From: Mundy, Ben - Oxfordshire County Council <Ben.Mundy@Oxfordshire.gov.uk>
Sent: 14 February 2023 10:55
To: DC Support; Rebekah Morgan
Cc: Transport CDC Minor
Subject: 22/03049/OUT Land West Of Oxford Close And North Of Corner Farm, Station Road, Kirtlington

Planning Application: 22/03049/OUT

Location: Land West Of Oxford Close And North Of Corner Farm, Station Road, Kirtlington

Description: Provision of eight single-storey and two-storey detached and semi-detached dwellings with access, parking and amenity space

SCALE: 1:500	DATE: 02.09.22	DRAWN: TW	CHECKED: DF	APPROVED: DF
JOB NO: 2207-015	DRAWING NO: VS01	REVISION: A

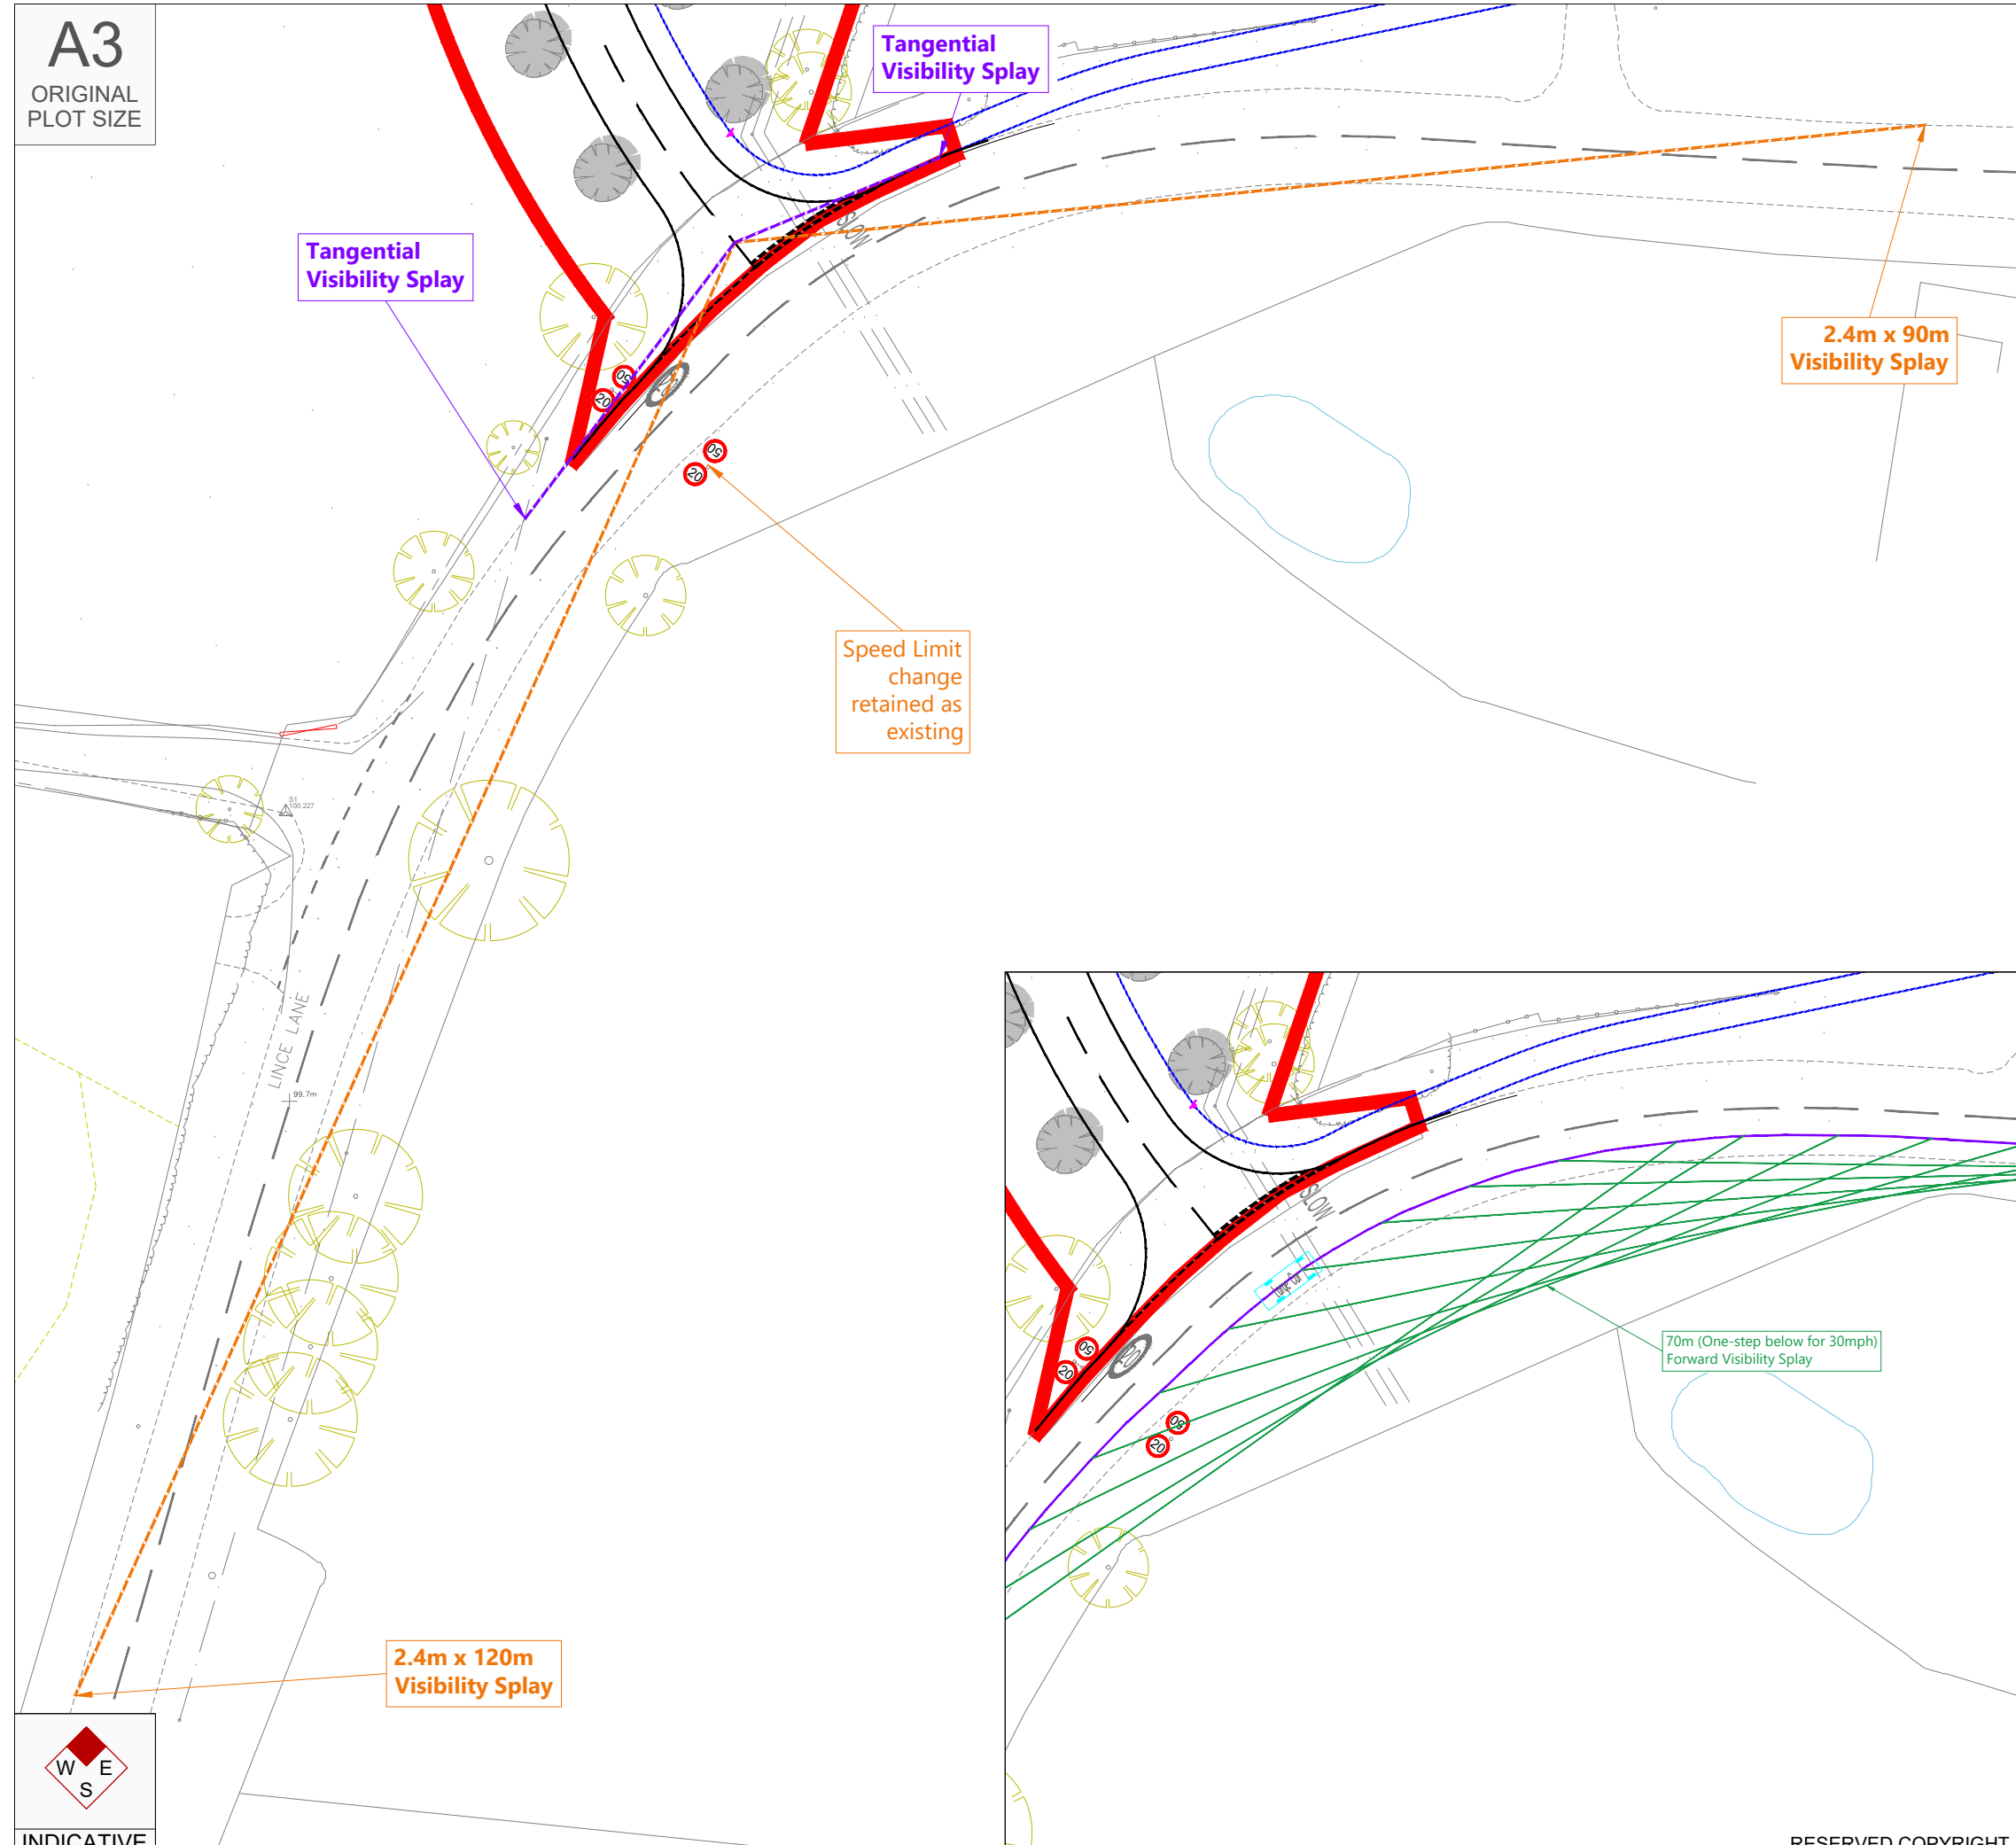
Speed Survey: I also stated to the developer within response dated 21/12/2022 that the speed survey was necessary. There has been significant concern raised over the visibility from the access from the local residents, due to the geometry of the surrounding road
